Our Ref FR111017-004/Letter 003
Contact Daniel Thompson

Date 7 November 2014

RE: KEMBLA GRANGE RESOURCE RECOVERY FACILITY

Figure 6 – Seasonal wind roses (from CALMET 2009)

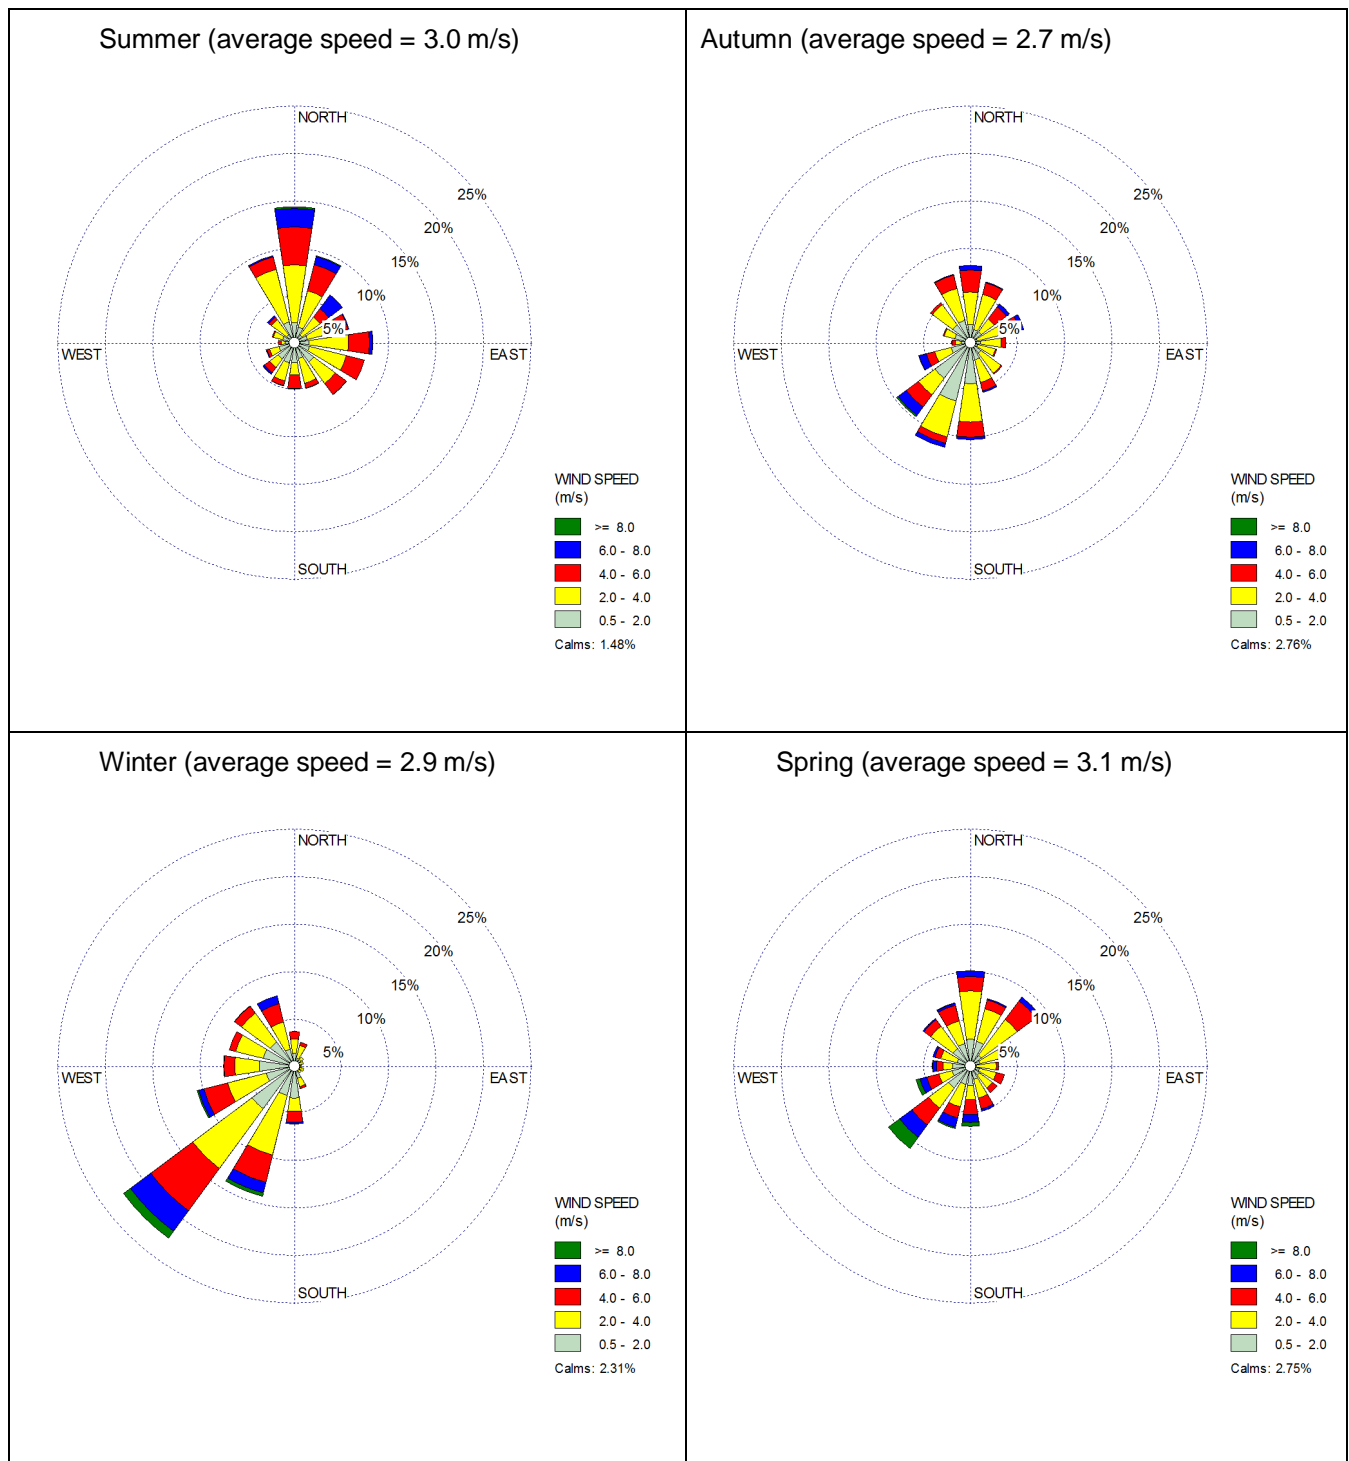
This highly uneven distribution of receiver sites is significant due to the seasonal variation in wind direction and strength. The Air Quality Assessment's own wind direction diagrams indicate winds from the north and northeast are typical of summer and spring.

The interpretation of these diagrams is that dust, odour and aerosol emissions from the KGRRF site will be blown into PAC's facilities with increased frequency and intensity in spring and summer due to these seasonal prevailing winds. Because the Air Quality Assessment does not model any sensitive receiver sites at these locations, the seasonal peak impacts of the facility are unknown. A revised Air Quality Assessment must analyse the impacts on locations west and south of the facility in order to provide a complete assessment. PAC believes that the Air Quality Assessment cannot meet the requirements outlined by the Director-General until it considers impacts in all directions around the KGRRF site.

Figure 15 – Predicted – Cumulative PM₁₀ 24-hour Average Concentration (with mitigation) µg/m³

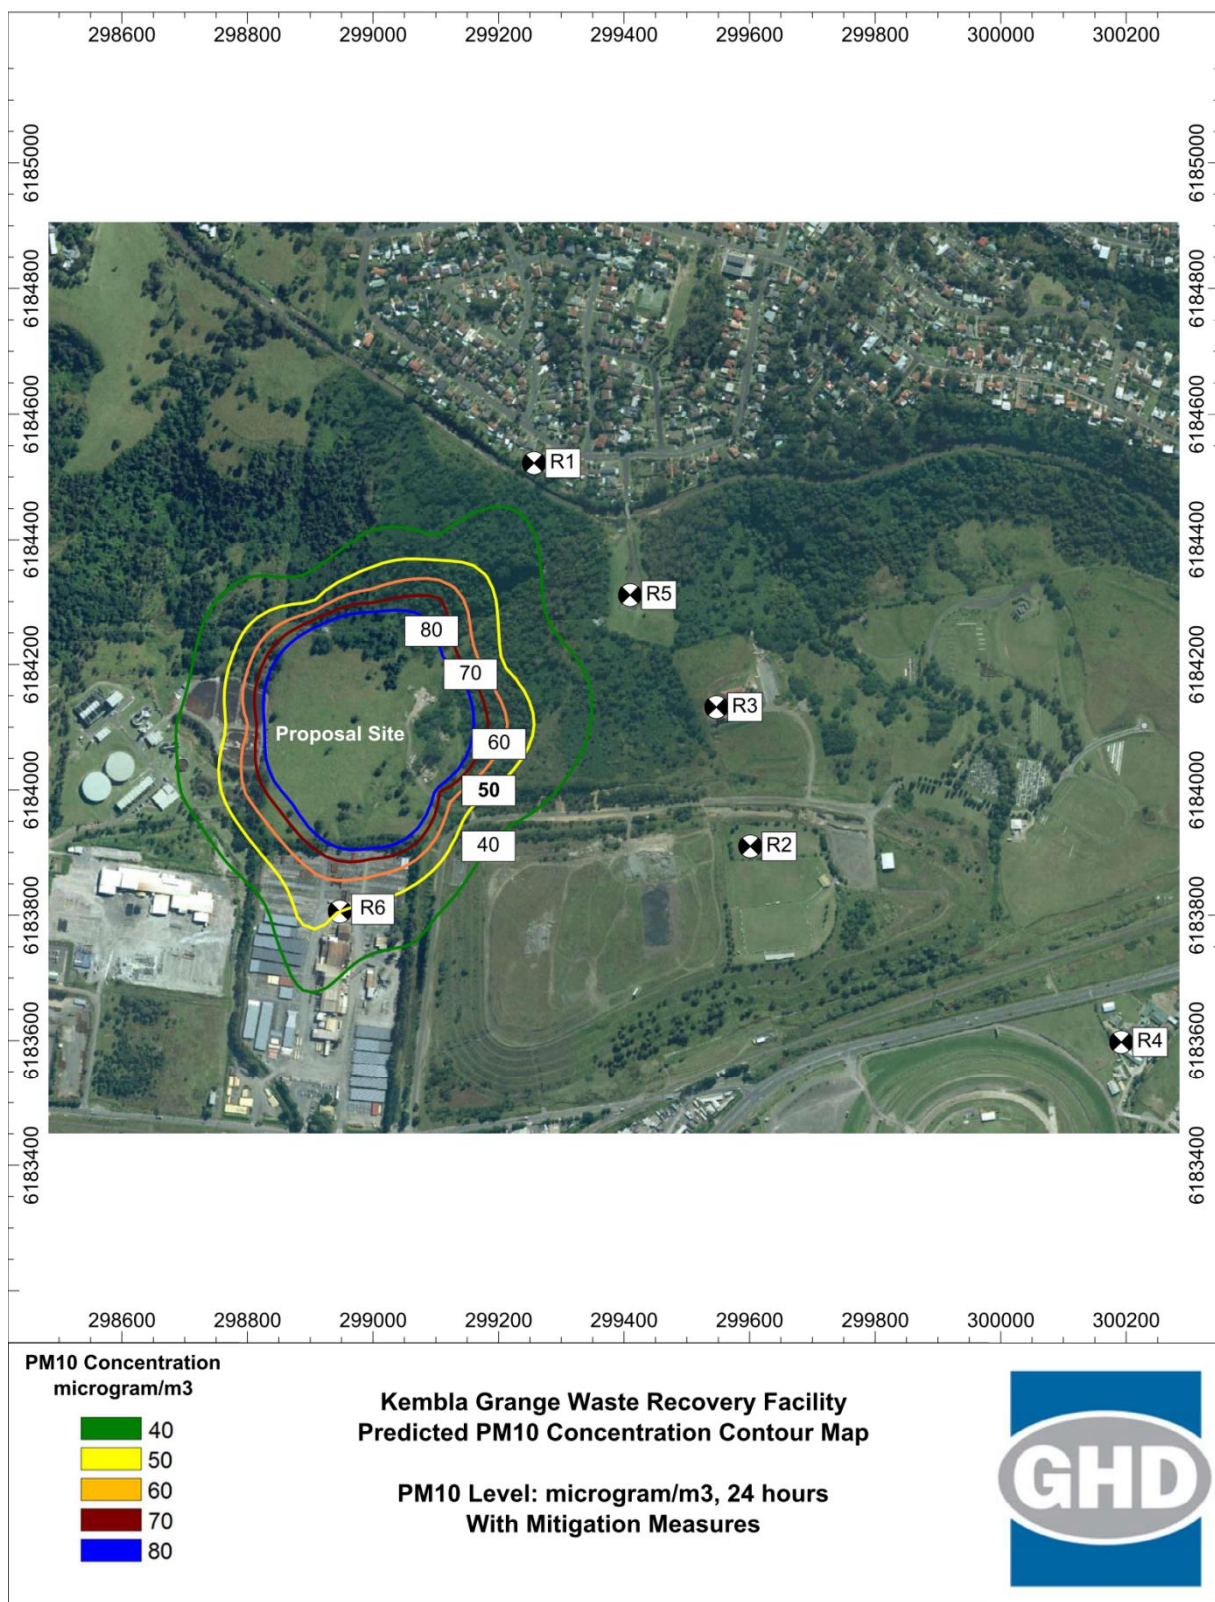
The Air Quality Assessment shows the results of the air quality predictions with mitigation measures in Figure 15. The assessment predicts that even with all mitigation measures in place, the PAC site at 66 West Dapto Road will be exposed to a maximum 24 hour average of 50 to 80 micrograms per cubic metre of PM₁₀ particles (See figure 5). Approximately half the site area would be exposed to PM₁₀ concentrations of 50 micrograms per cubic metre or more. The impact at 17 Reddalls Road would be less with levels between 40 and 70 micrograms per cubic metre.

The Air Quality Assessment notes in Table 13 that the regulatory criteria for exposure to PM10 particles over 24 hours is 50 micrograms per cubic metre. This level is exceeded significantly at PAC's 66 West Dapto Road site.

Figure 16 – Predicted – Cumulative TSP Annual Average Concentration (with mitigation)  $\mu\text{g}/\text{m}^3$

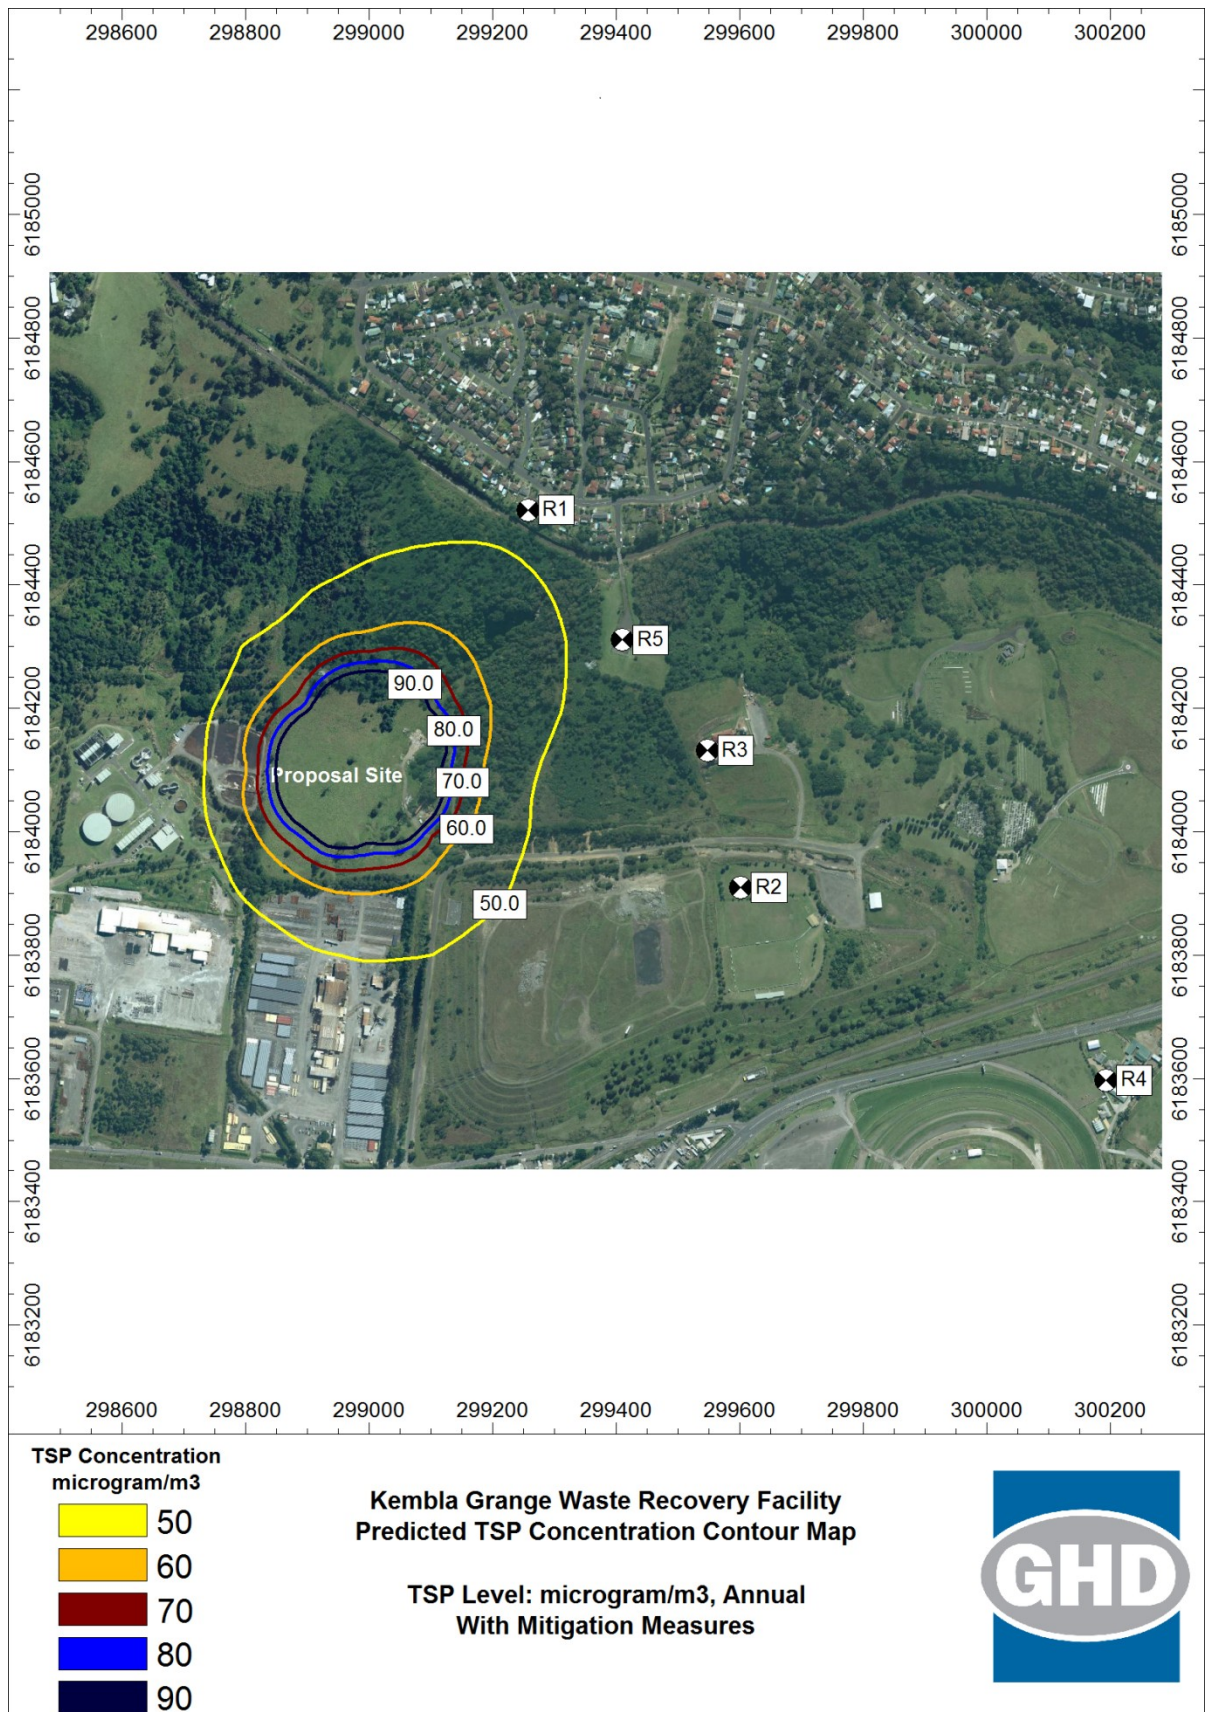
Total Suspended Particles measured in micrograms per cubic metre of air is directly measuring the concentration of fine particles in the atmosphere. The Air Quality Assessment indicates a background level of 42.6 micrograms per cubic metre. The proposed expansion of the KGRRF would result in the predicted

annual average concentration of TSPs rising to between 50 and 60 micrograms per cubic metre on the northern quarter of PAC's facility at 66 West Dapto Road even with all proposed mitigation measures implemented (see figure 4). This is a 25%-50% increase in fine particle levels on this part of the site which is used for the storage of motor vehicles.

Figure 19 – Predicted Peak Odour Contour Map, OU with building ventilation and biofilter

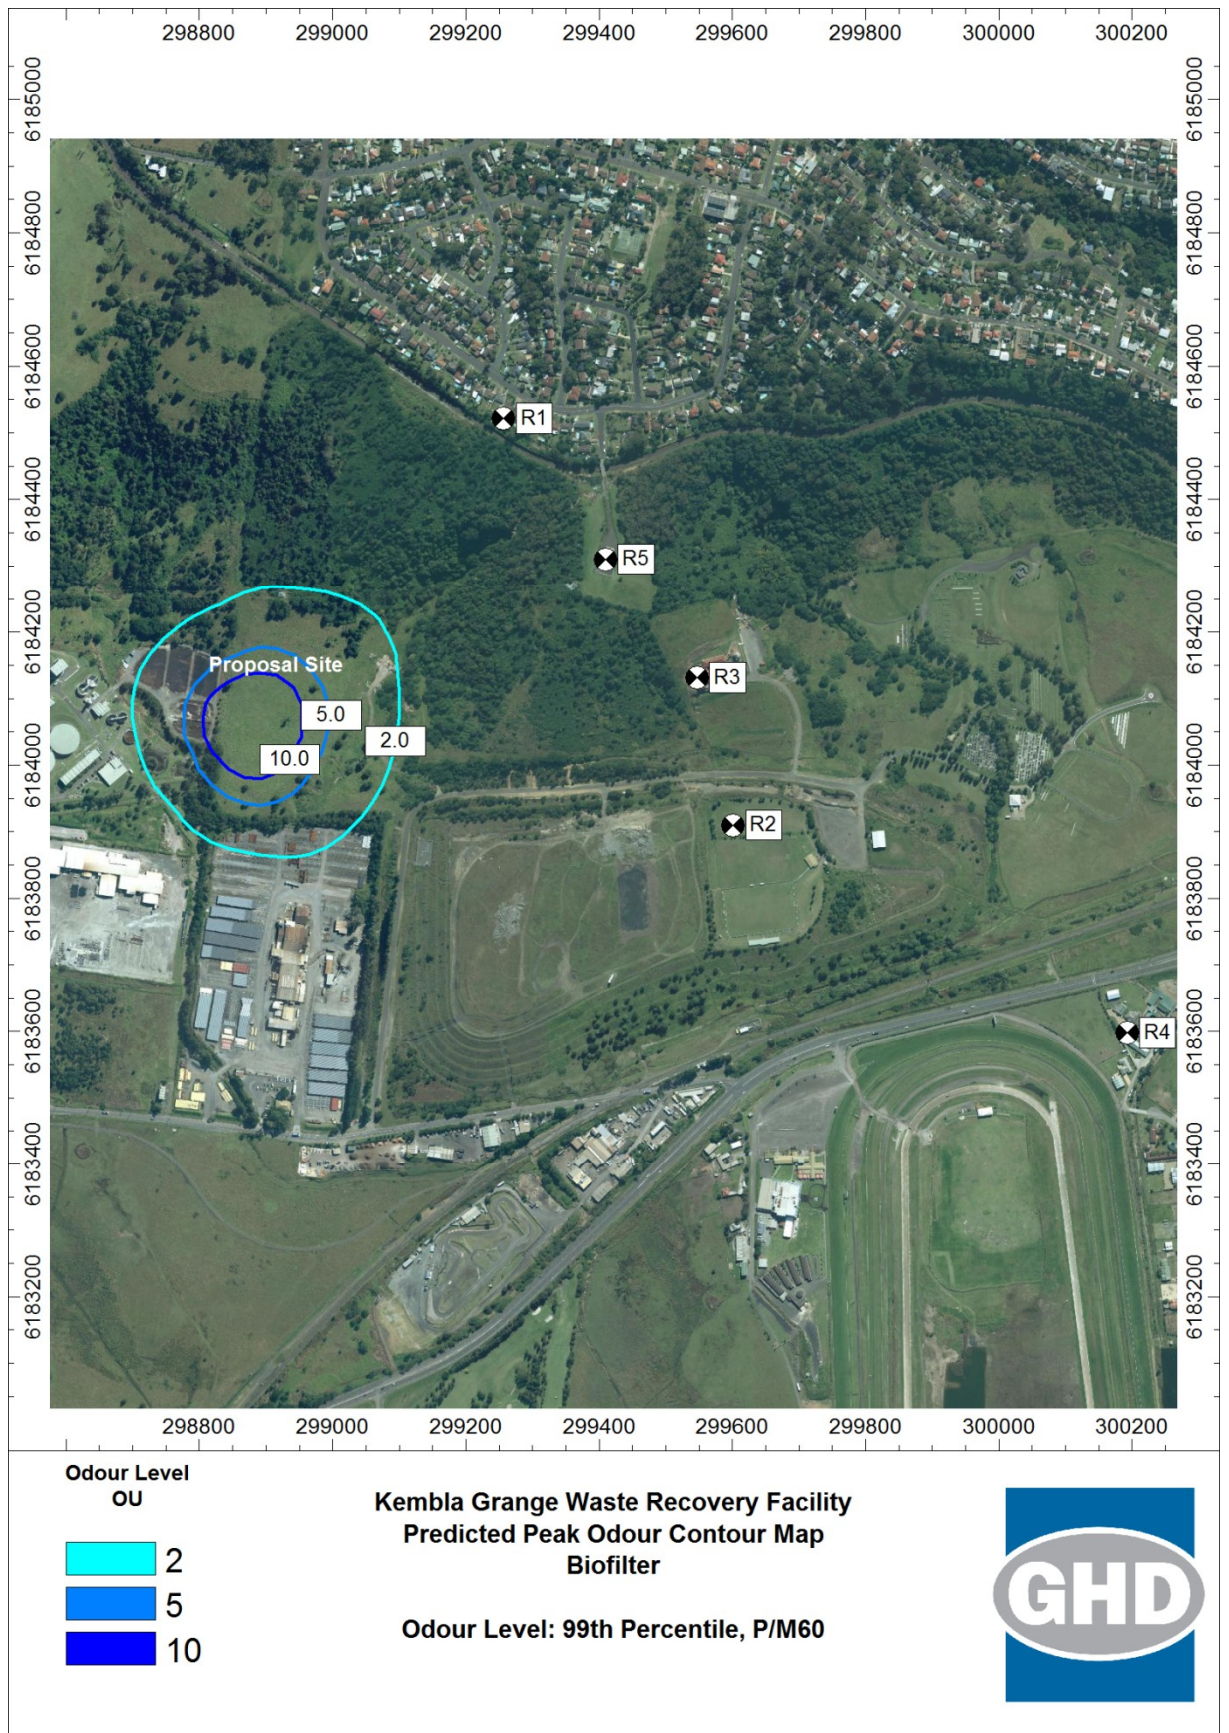
The KGRRF facility would emit unpleasant odours to an even greater extent than currently occurs due to the expanded operations. Even with all proposed mitigation measures there would still be an unacceptable odour at the northern end of PAC's site at 66 West Dapto Road (See figure 6). This odour could over time permeate the cars stored on this section of the site, with PAC required to introduce an enhanced cleaning regime to maintain these vehicles in an acceptable condition. Furthermore, odour would have an impact on the amenity of the surrounds for staff.
